Our Ref: AL/31/19/HH

**Town & Country Planning Act 1990 (as amended)
Town & country Planning (Development Management Procedure) (England) Order 2015
Application for Planning Permission for Works or Extension to a Dwelling**

Development Single storey rear extension, replacing front windows

Location 16 Church Road Aldingbourne

16 Church Road, Aldingbourne - 3034.19.CC

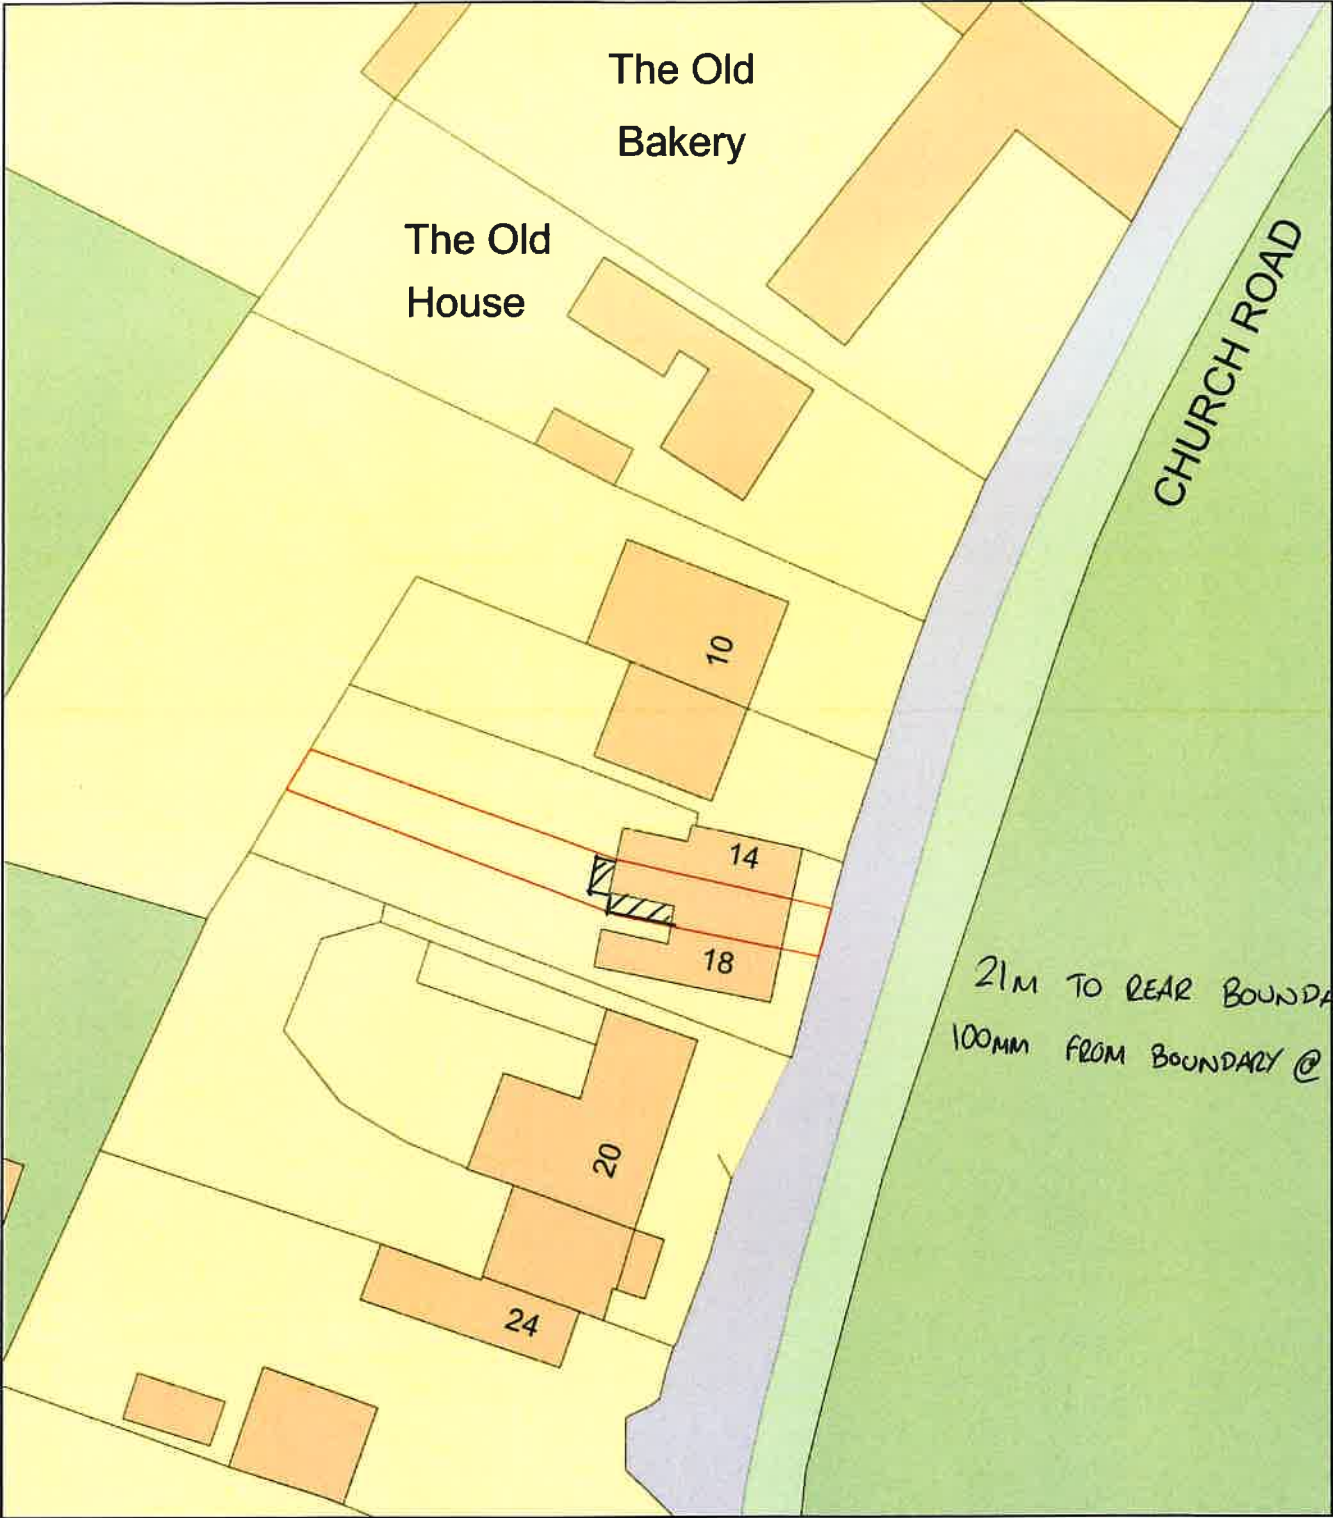
Block Plan

Please submit 1 electronic or 3 paper copies of a block/site plan which includes dimensions from the proposed rear extension to the site boundaries.
